**Consultation Response from KC,
Highways Development Management****2025/90413 Land adjacent, 40, Manchester Road, Slaithwaite, Huddersfield, HD7 5JA****Demolition of existing garages and erection of two dwellings and associated works****Date Responded: 16-9-2025.****Responding Officer: Mark Berry****Responding Ref: 1-32-4.**

This application seeks approval to the demolition of existing garages and erection of two dwellings and associated works at land adjacent, 40, Manchester Road, Slaithwaite, Huddersfield.

Proposed site plan (1:200).

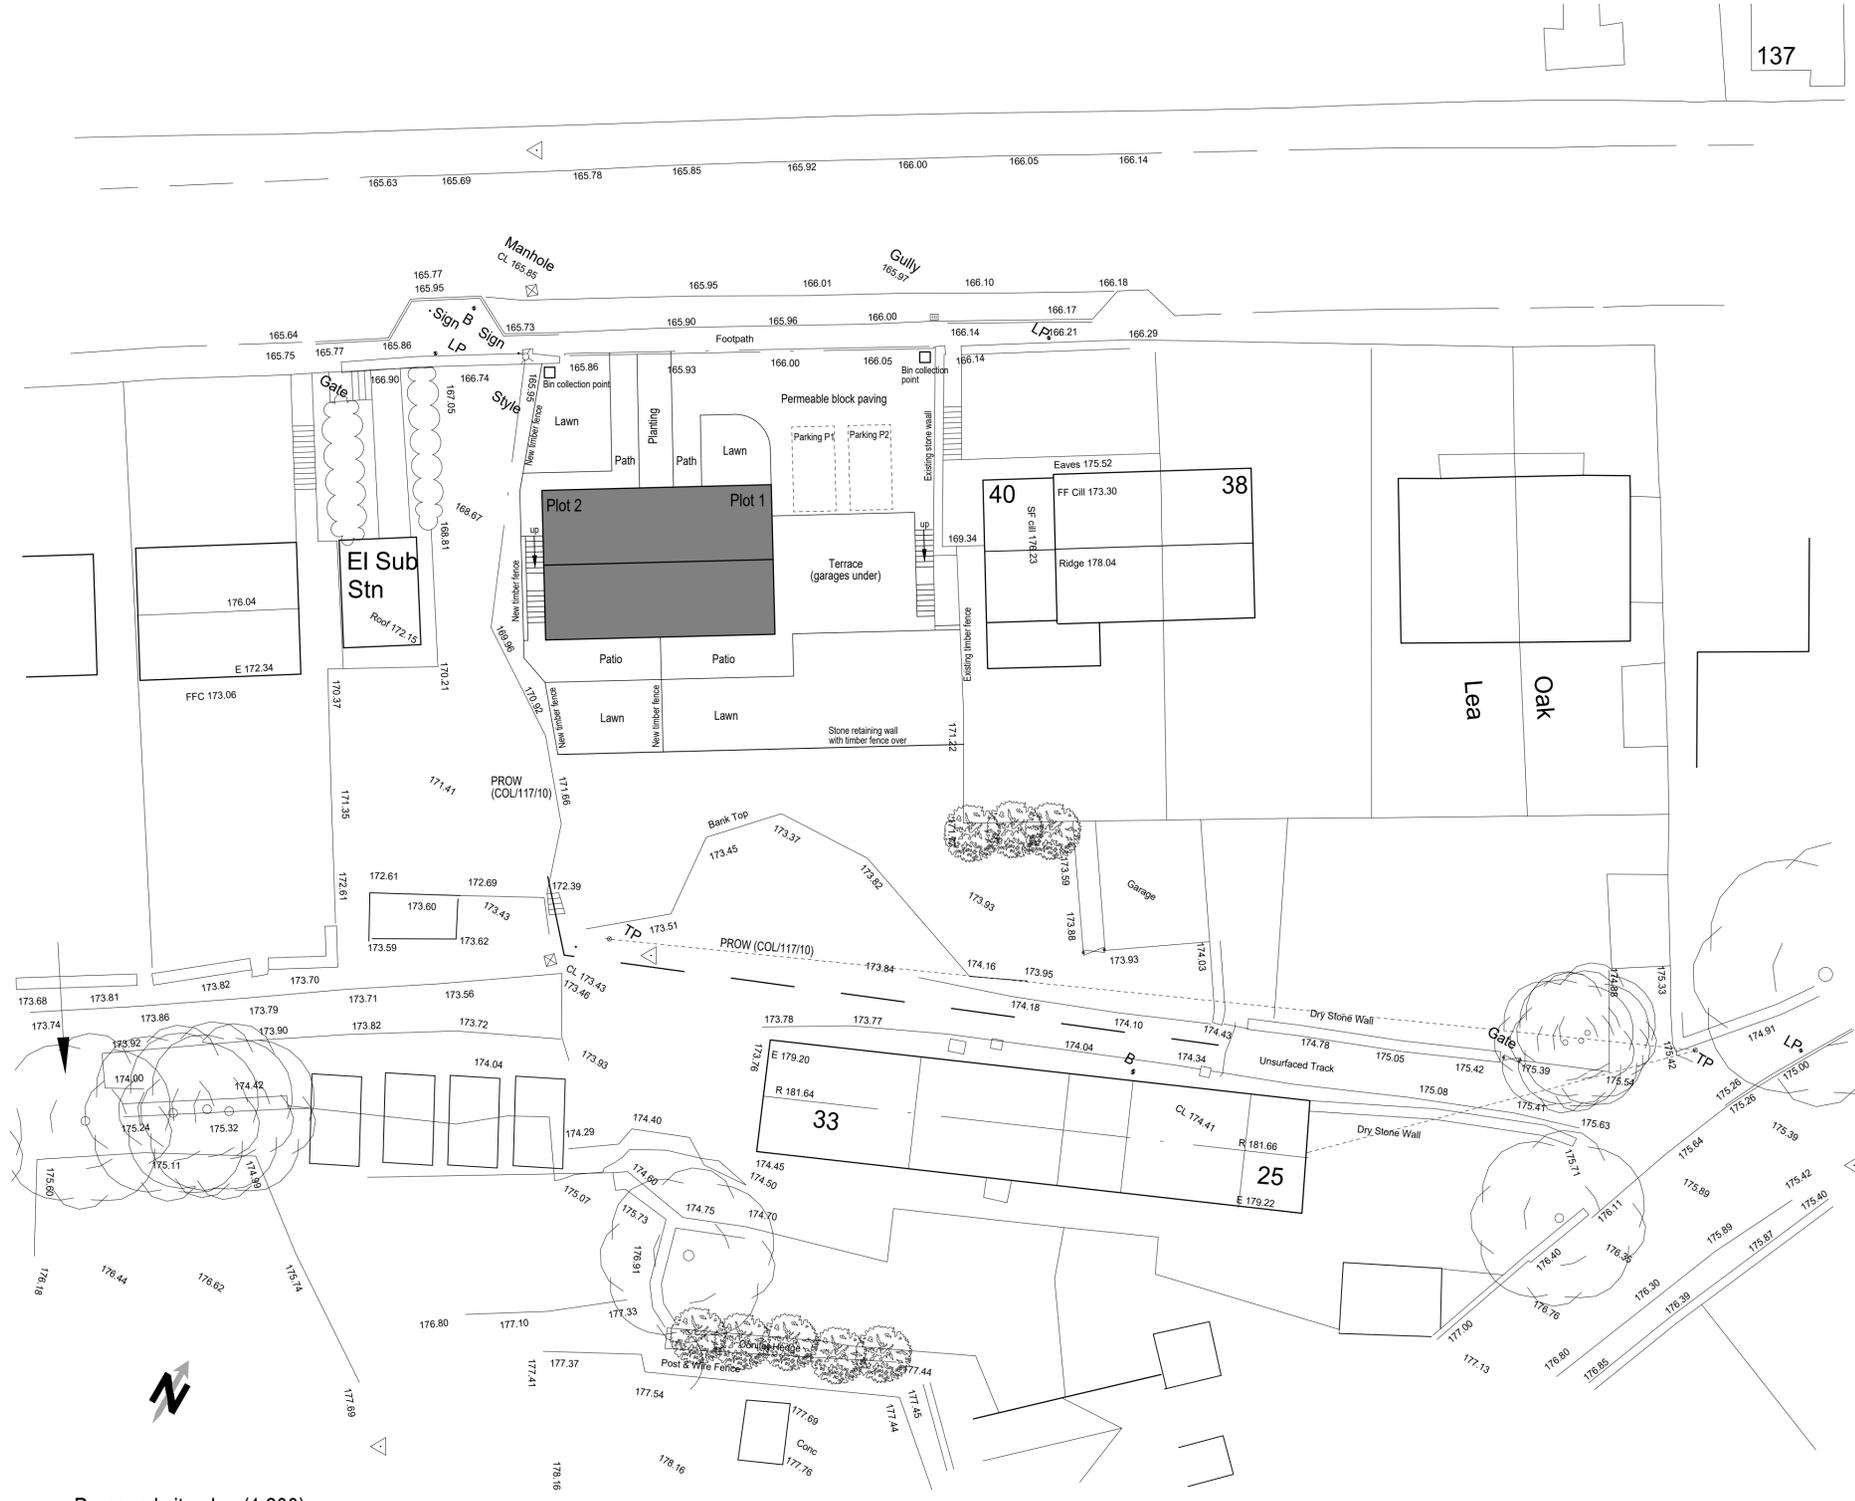
1, The proposed dwellings are shown to be located on the western side of the site against the boundary with the PROW and close to the Bus Stop. This means access to the western plot will be obstructed by a bus standing at the stop. There will also be conflict with pedestrians standing waiting for a bus and users of the PROW. HDM would recommend that the dwellings are re-sited to the opposite side of the site.

2, The plans don't clearly show the proposed driveways to the frontage of the garages. The driveways should be clearly shown and dimensioned. The point of access for the PROW onto the back of footway along Manchester Road should also be clearly shown to demonstrate that access is not compromised.

4, Bin collection points should be shown to be provided to both dwellings to enable bins to be presented on collection day without either obstructing the highway or proposed driveways.

The revised plans show the proposed garages and driveways located on the eastern side of the site which should remove the potential conflicts referred to in point 1 above. Internal vehicle turning is also shown to be provided.

The proposed driveways are shown to the frontage of the garages; the dimensions of the proposed garages are shown to be 6.0m x 3.0m and bin collection points are shown to be provided to both dwellings.

**Proposed block plan (1:500).**

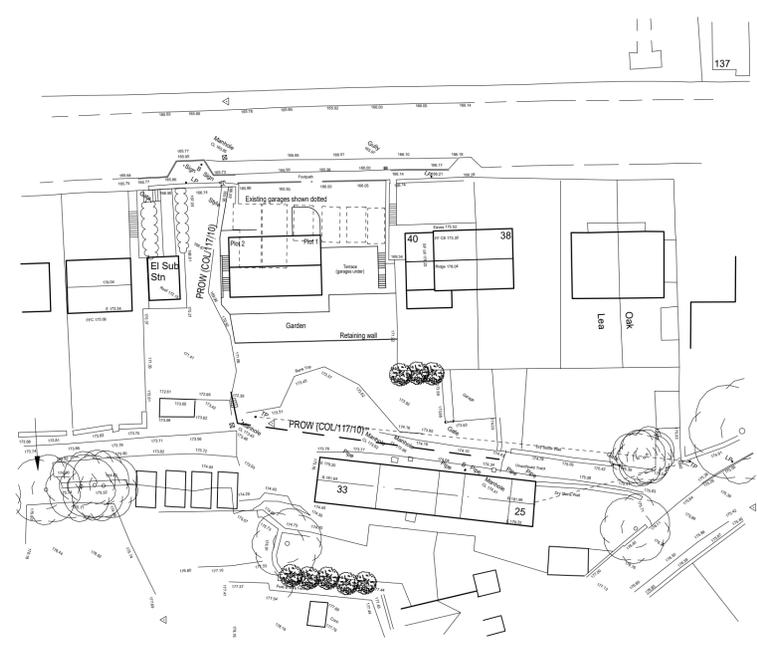
3, The dimensions of the proposed garage need to be confirmed. 6.0m x 3.0m is the minimum standard acceptable.
